Planning Application No: 3/2024/0007

Proposal: Conversion of existing single-storey double garage to annexe and erection of garden shed.

Location: 37 Middle Lodge Road Barrow BB7 9XS

PROPOSED PARKING
LAYOUT.
1:500

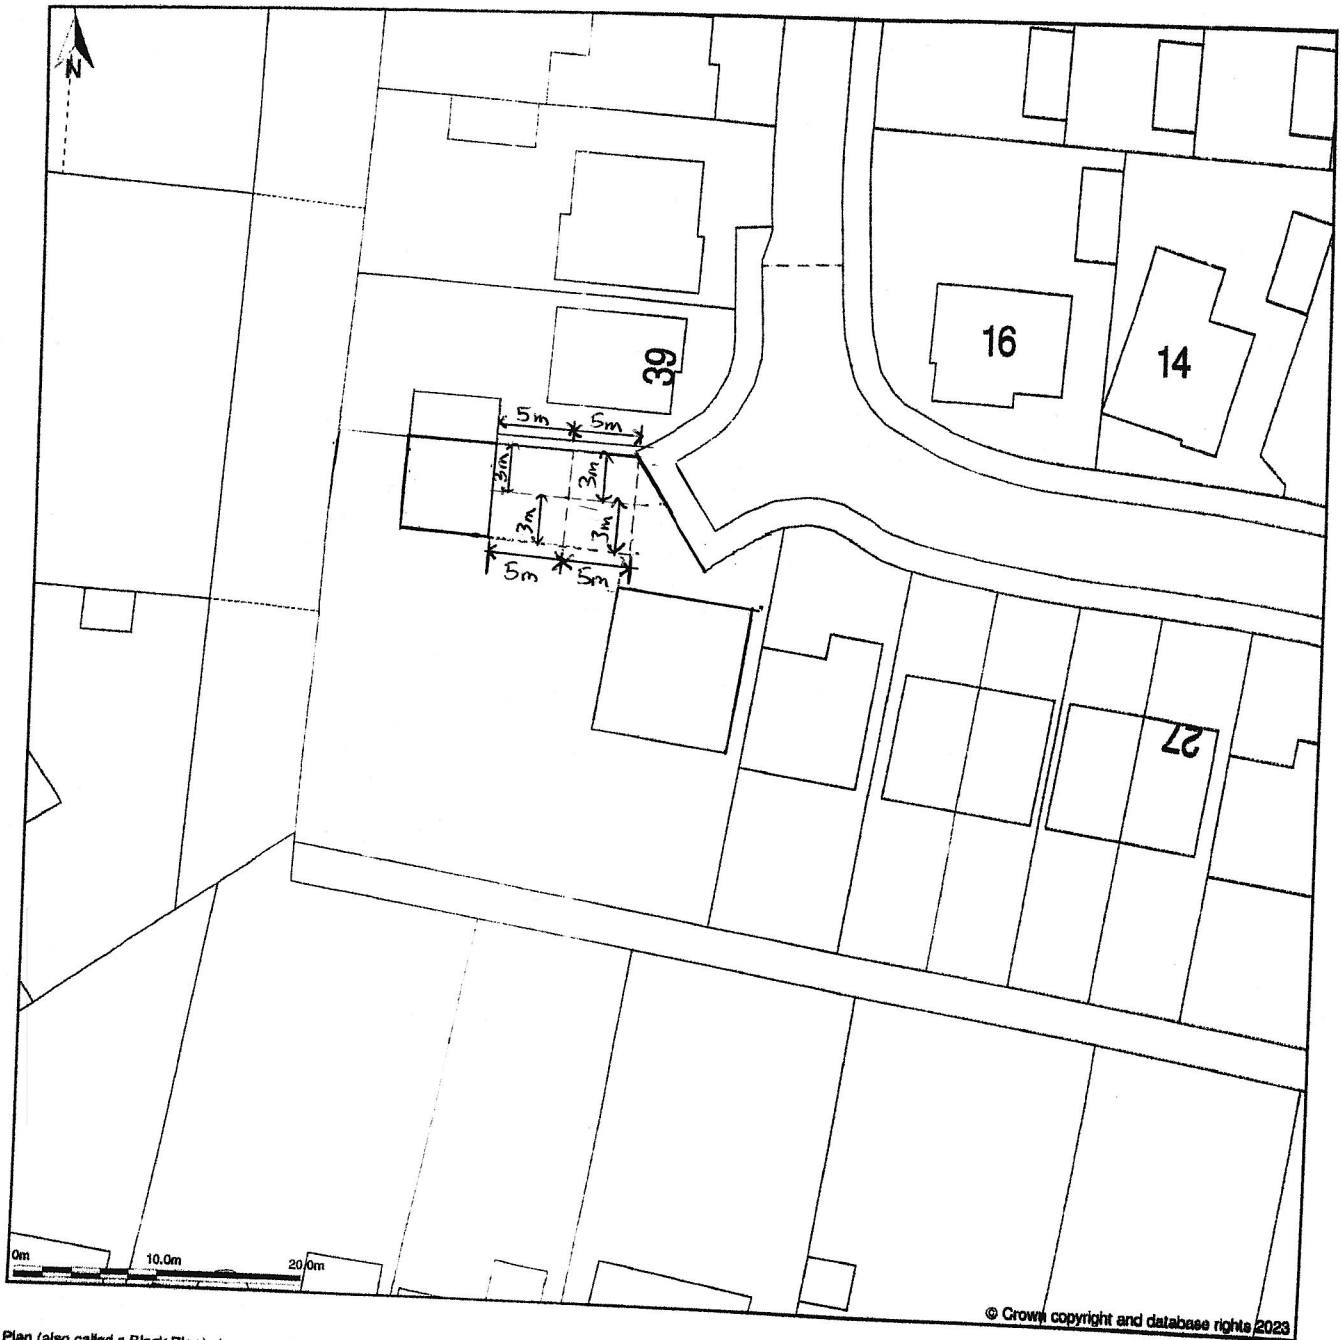
No parking plan has been submitted with this proposal. A parking plan is required to show parking standards for the property and proposed annex can be met within the curtilage of the property. Parking on a turning head is not acceptable for highway safety reasons.
